Project Name: cPort Credit Union Project ID: 2017-130
Address: 50 India Street CBL: 028 P023001
Applicant: cPort Credit Union, Inc.
Planner: Caitlin Cameron, Urban Designer

On October 12, 2017, the Planning Authority approved a Level II Site Plan application for the cPort Credit Union mixed use building at 50 India Street. The four-story building includes commercial space for the credit union on the first two floors and one residential unit occupying the upper two floors. The decision is based upon the application, documents and plans as submitted. The proposal was reviewed for conformance with the standards of Portland's Site Plan Ordinance and the India Street Form Based Code.

TO: Caitlin Cameron, Planner
FROM: Lauren Swett, P.E.
DATE: September 25, 2017
RE: 50 India Street – cPort Credit Union, Level II Site Plan Review Response to Comments

To: Caitlin Cameron - Planner
From: Keith Gray, PE – Senior Engineer, DPW
Date: September 21, 2017
Re: 50 India Street (2017-130) cPort CU – Level II Site Plan Application

3 SIDEWALK RAMP DETECTABLE WARNING PANEL
NOT TO SCALE

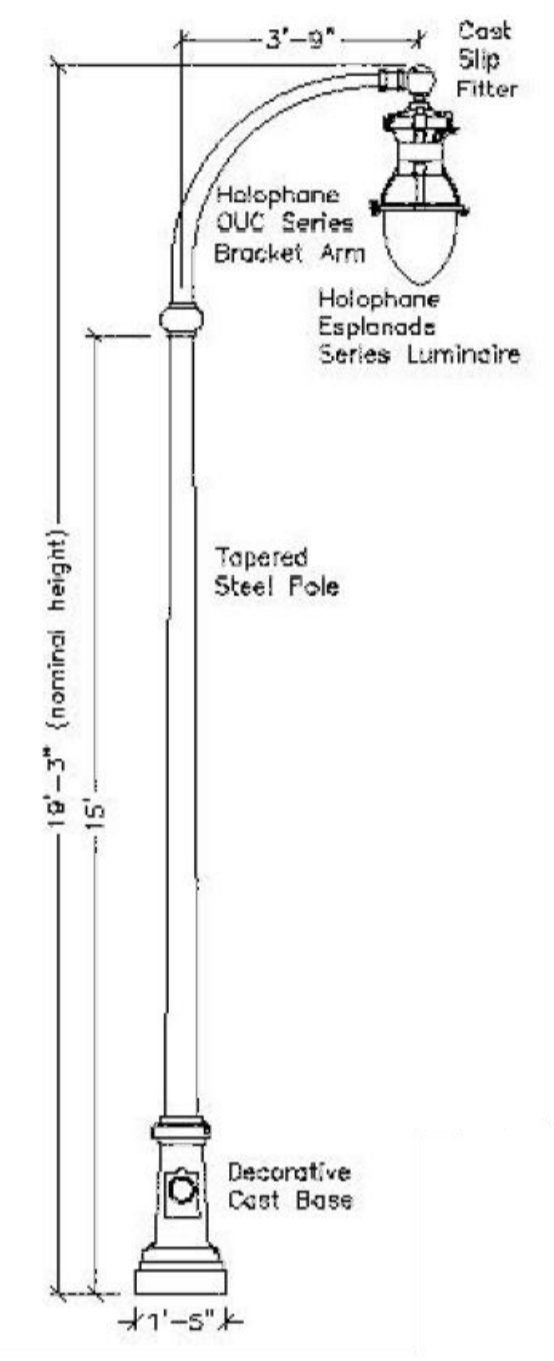
3. The final detail of the detectable warning panel shall be shown on the final plans (Sheet C-301 Detail 3), subject to the Department of Public Works selecting a final technical manual specification.

**C-103**

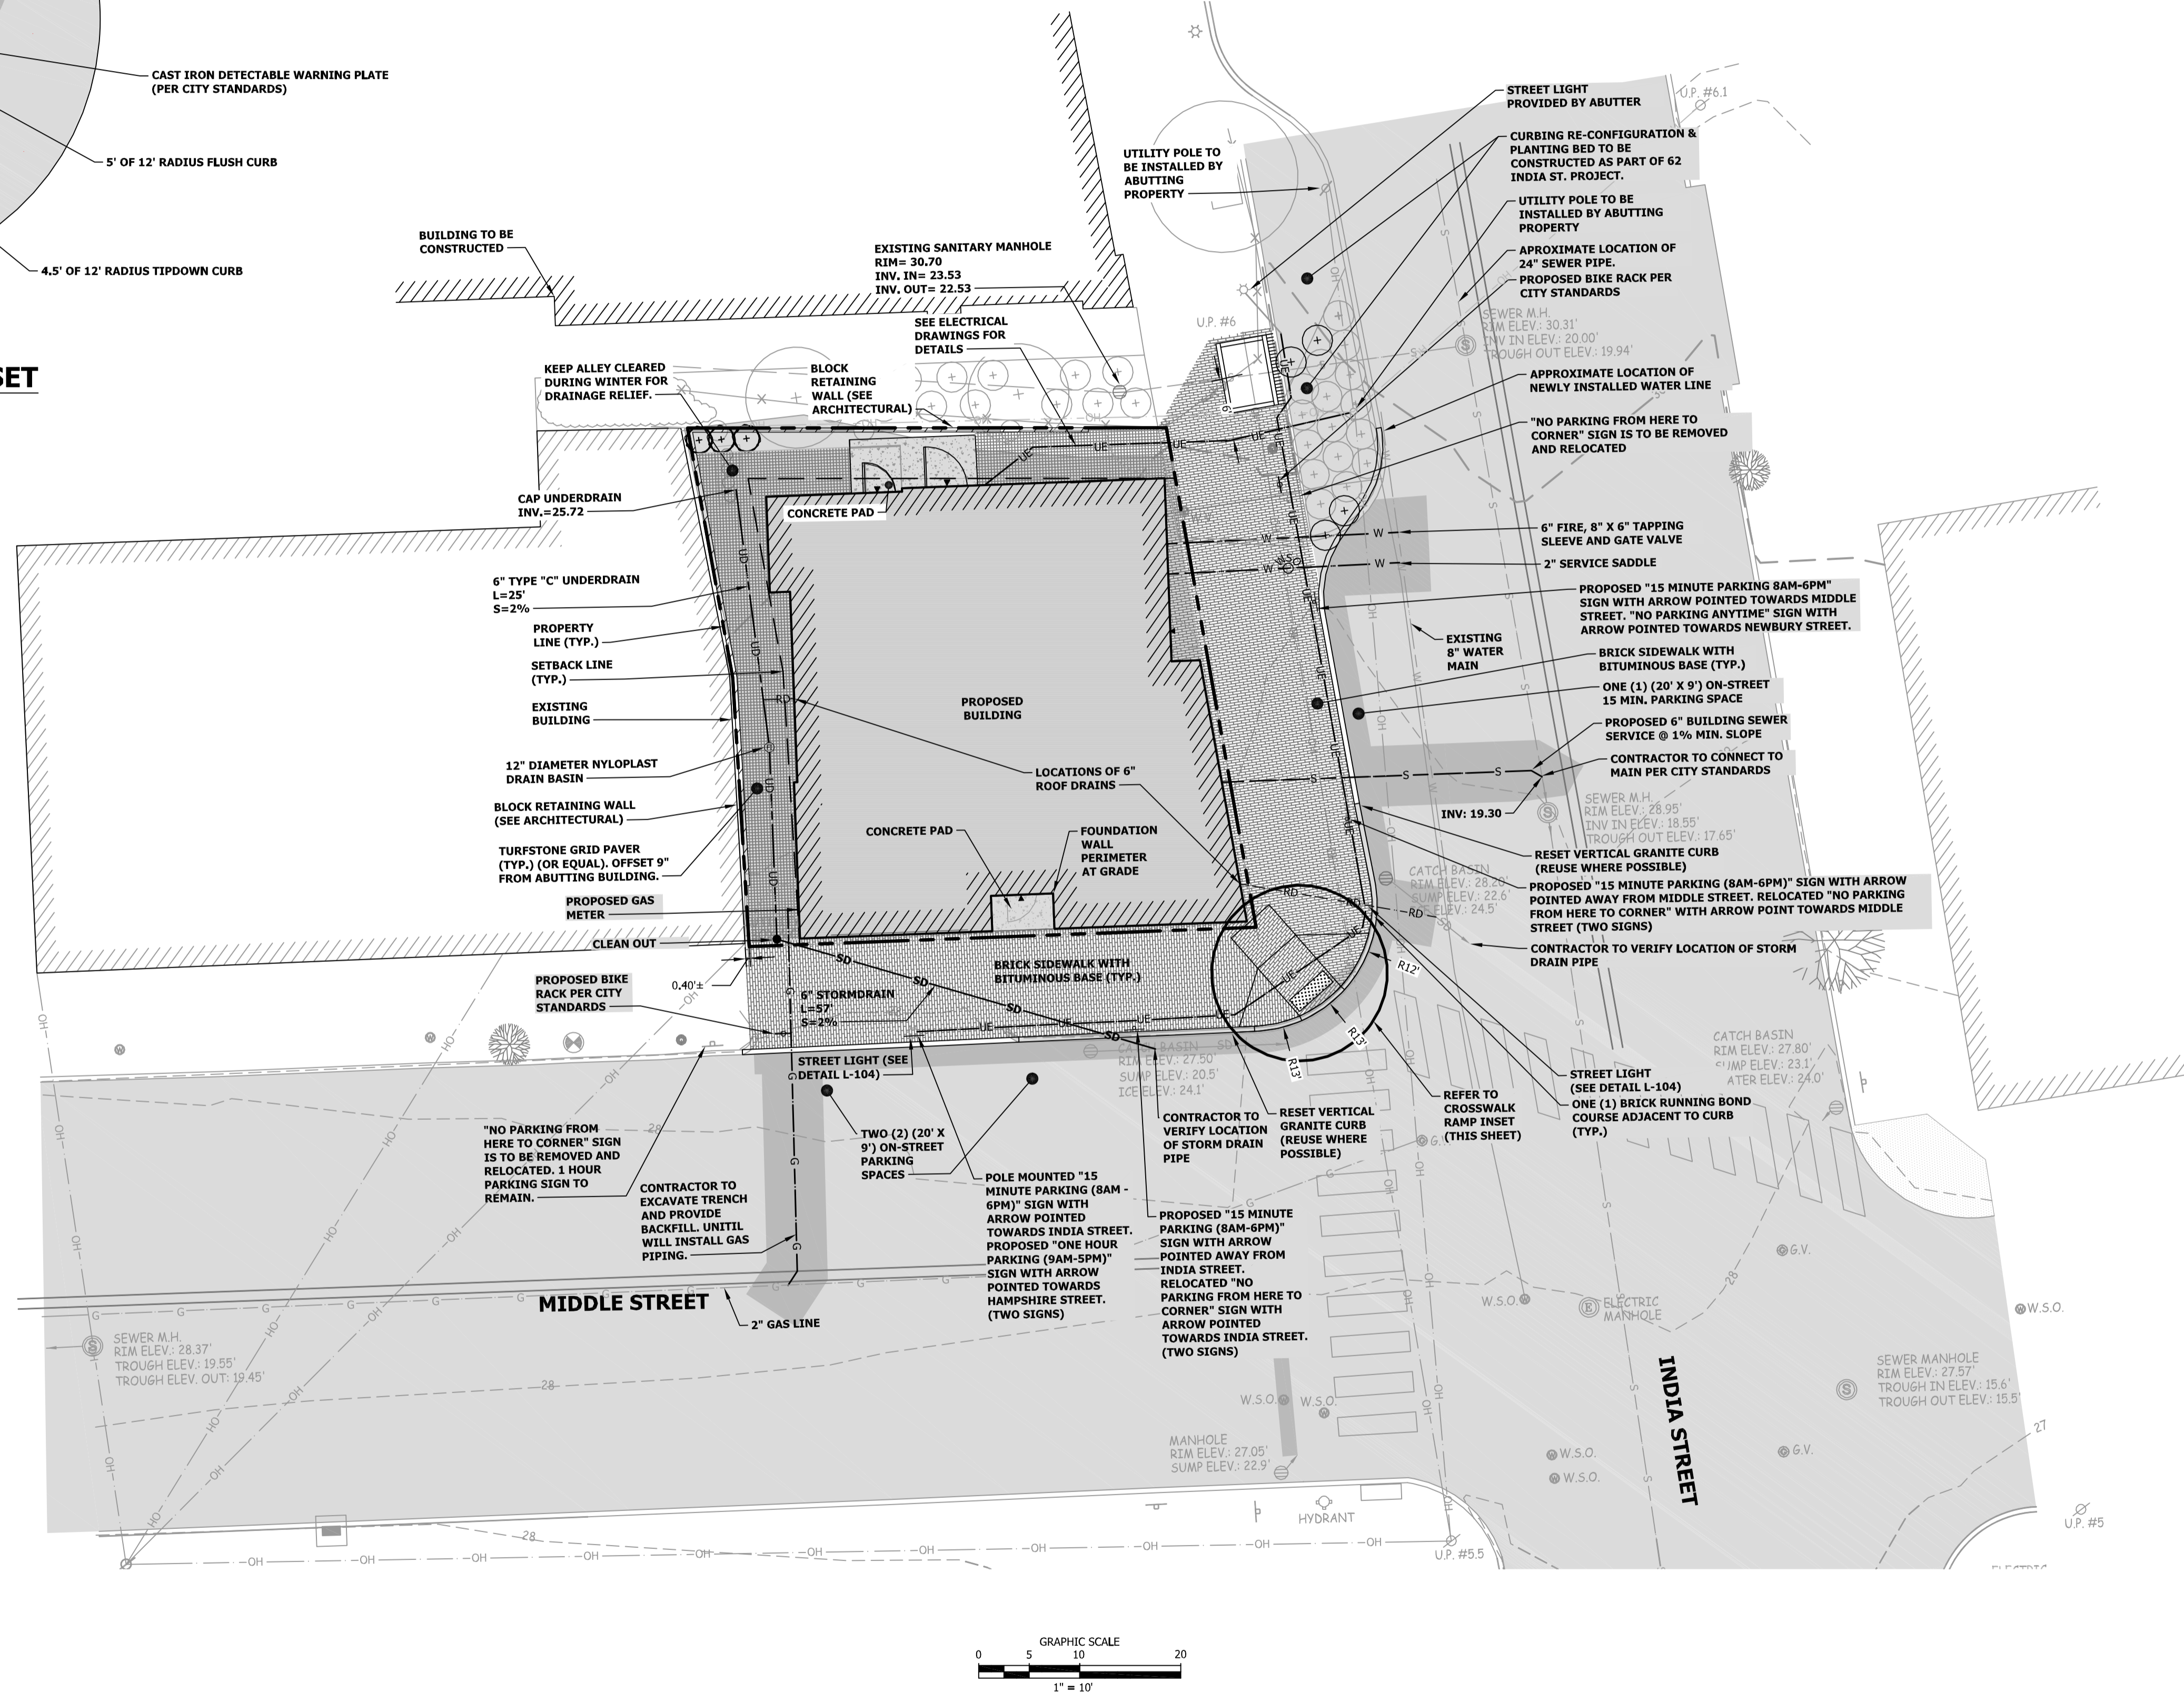
- The applicant is closing a driveway on Middle Street. The applicant should note that Middle Street in this area is a Pavement Moratorium Street and therefore the curbing work that is proposed may result in Moratorium fee requirements. Coordination with City staff is suggested on this item.

Status: The applicant has coordinated with DPW on this issue and I have no further comment.

Final Status: I have no further comment.
